**Ref No:** F2020/00663

Application No: SSD-10831778

**Re: Randwick City Council submission on the State Significant Development SSD-10831778 – Sydney Children’s Hospital Stage 1 and Children’s Comprehensive Campus Centre (SSD-10831778)**

4 PROPOSED SHADOWS - JUNE 21 - 9AM
1:1500

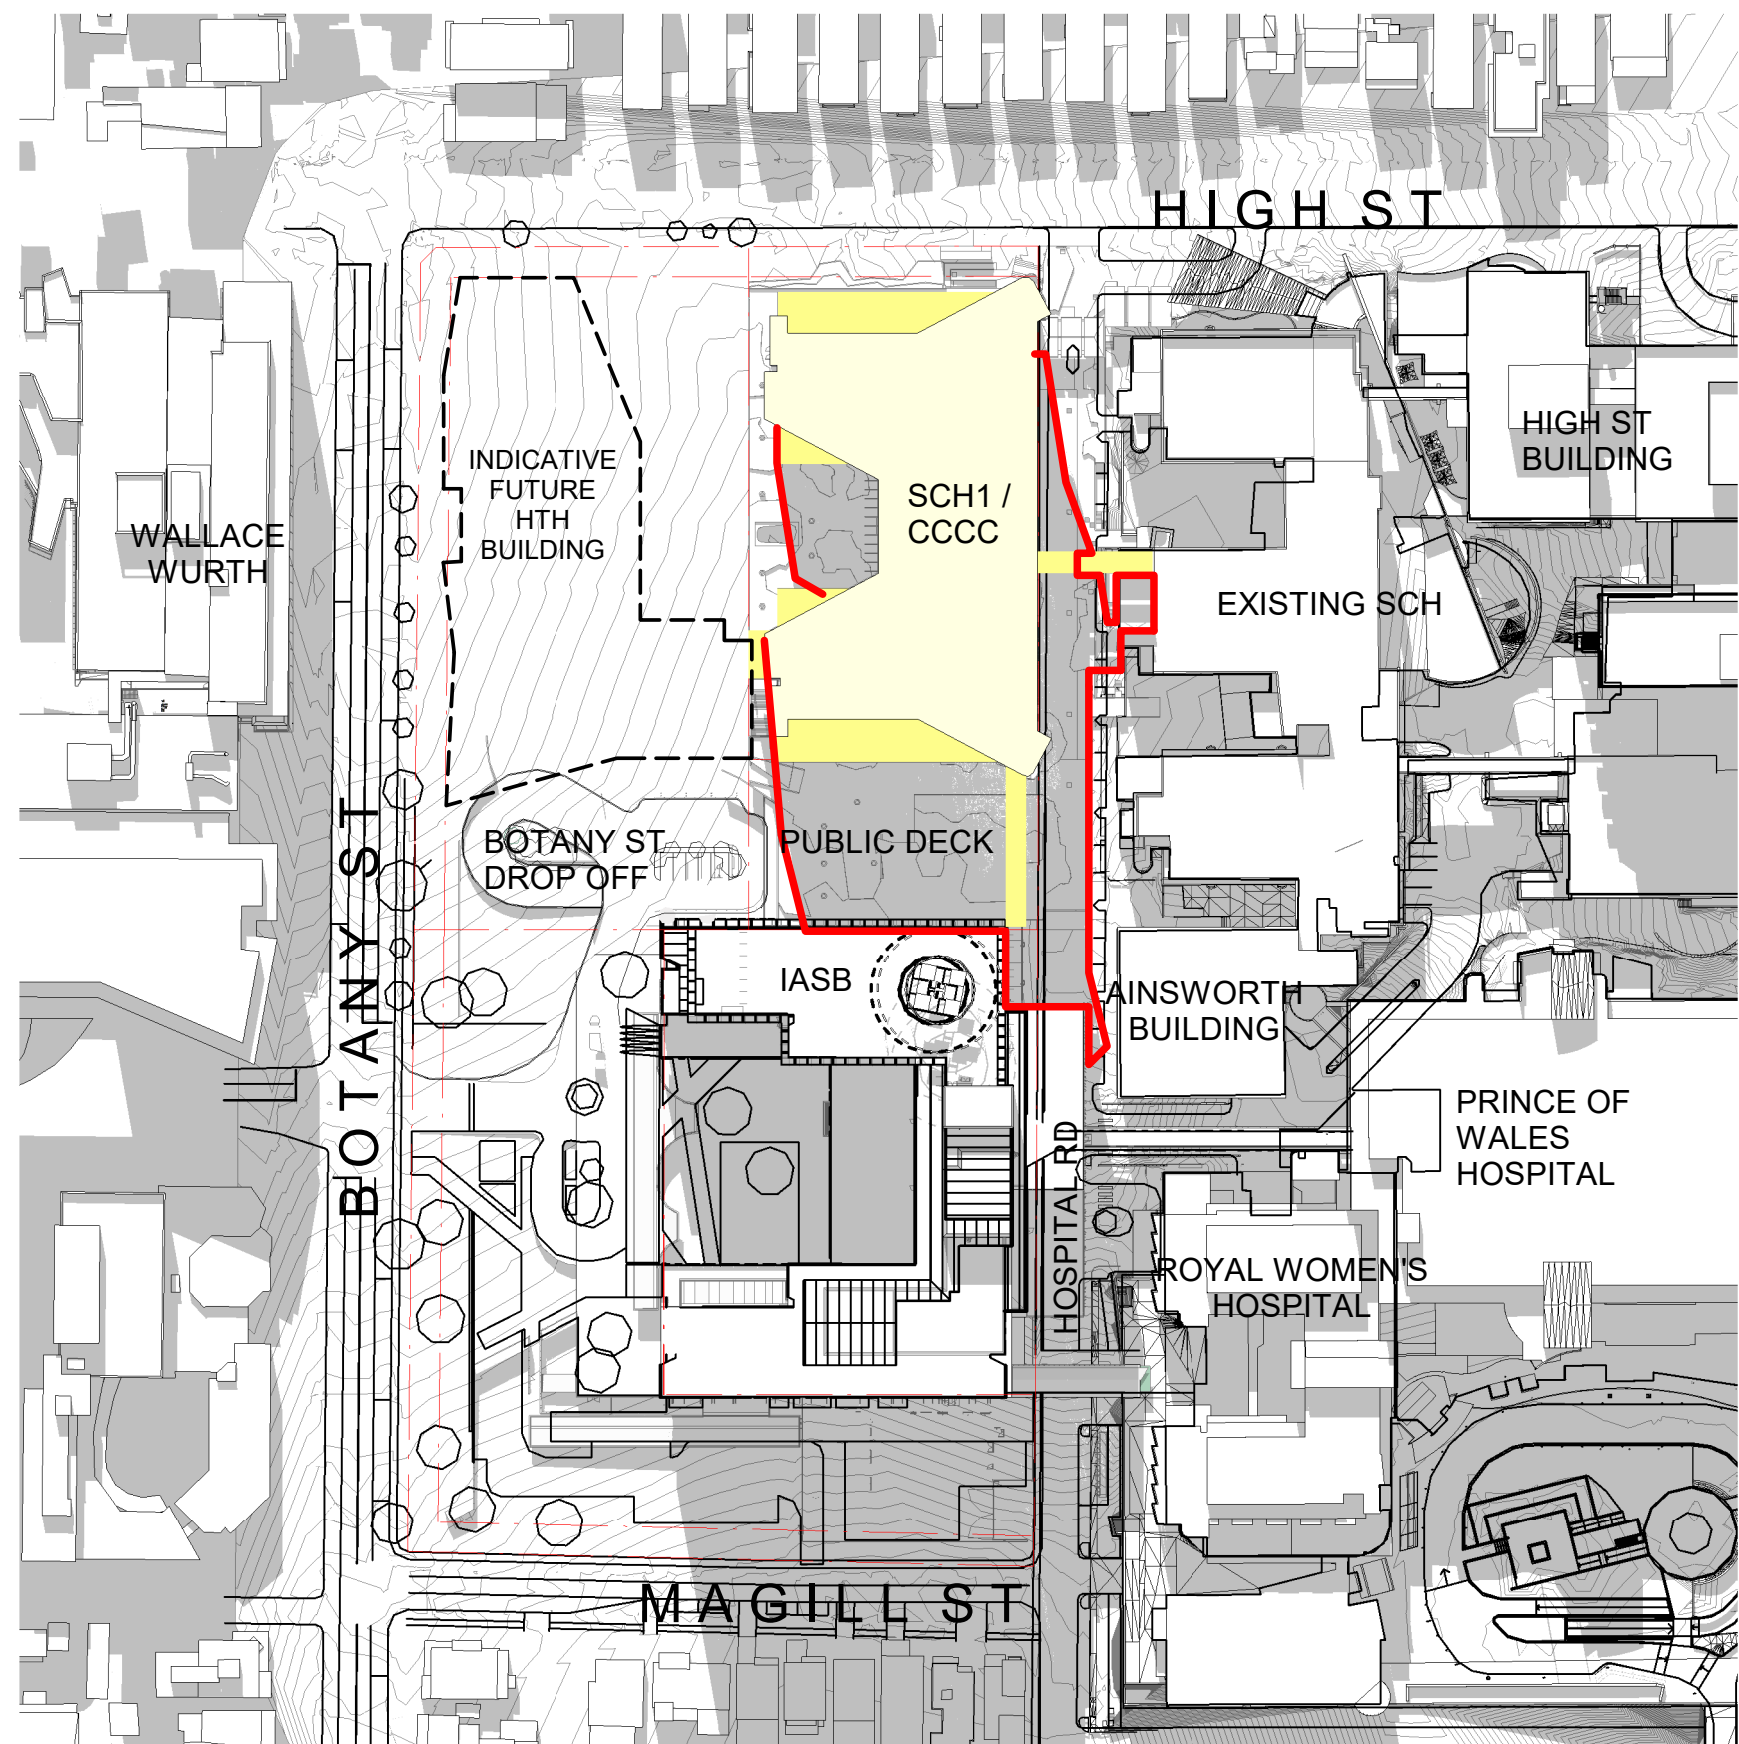
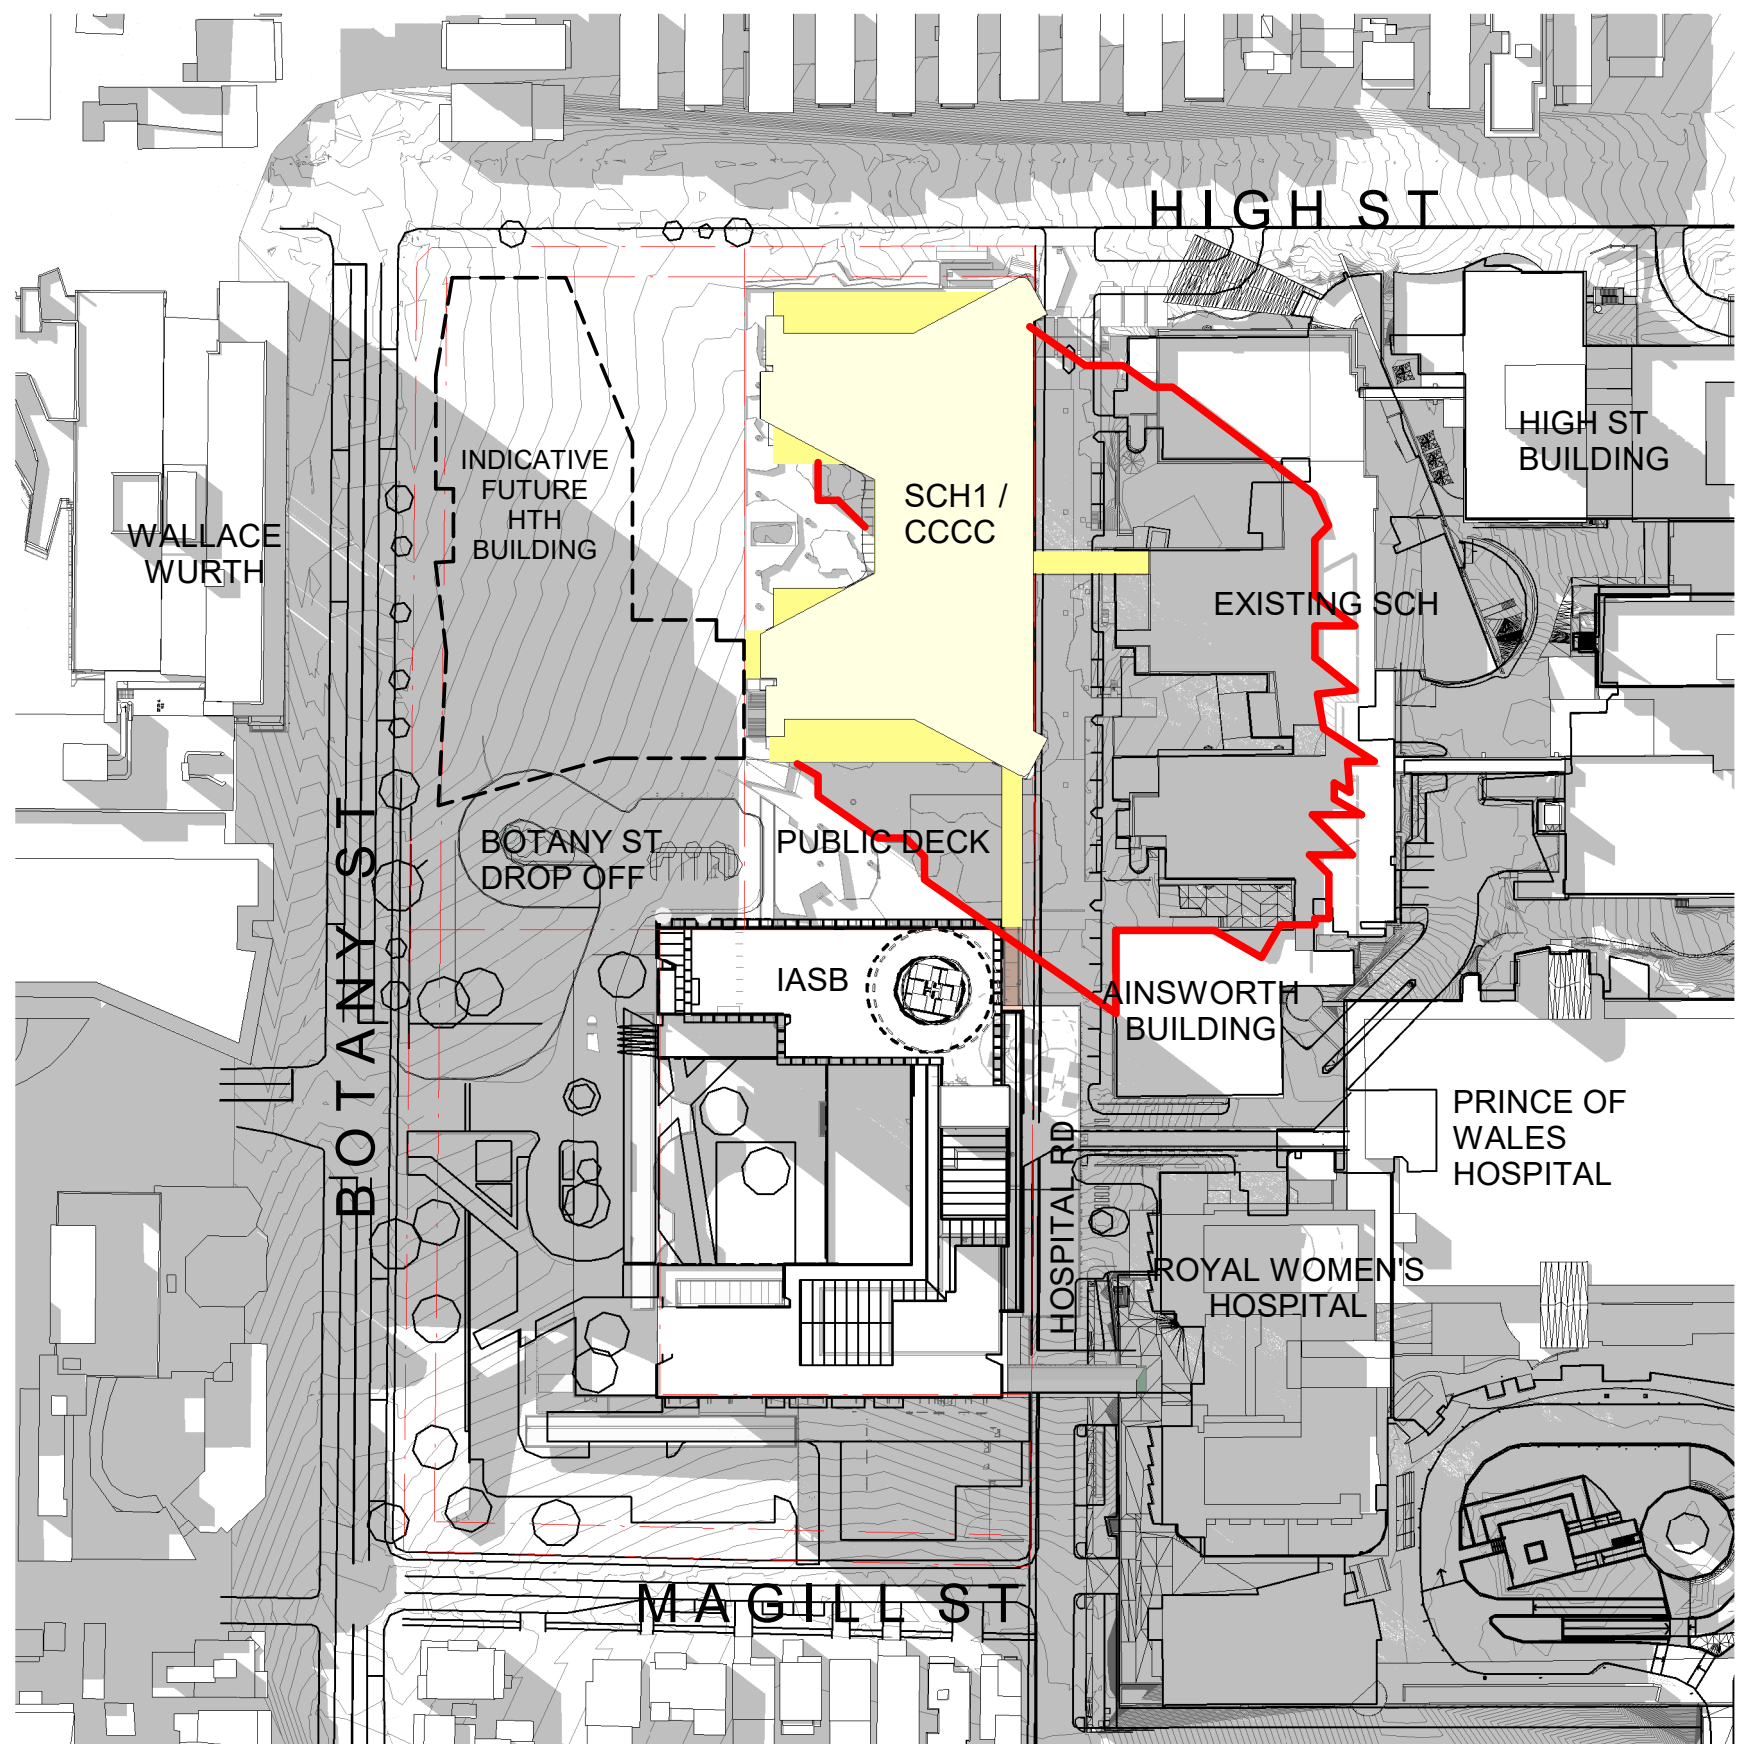
31. The proposed building will significantly overshadow the proposed children's play area through most of the year and particularly during the winter months, resulting in an inappropriate location for a children's play area. A location that receives sunshine, with a northern aspect would be preferable. Locating the play area to the north of the building, within sight of the proposed café, would provide a safer and more welcoming location. Alternatively, a north facing play area on an upper level terrace or roof of the building could be considered.

32. The north leg of the building, as proposed, blocks mid-morning sunshine from reaching the plaza. Reshaping and or increasing the height of the undercroft of the north west corner of the building should be explored to improve solar access to the plaza in the mid-morning.
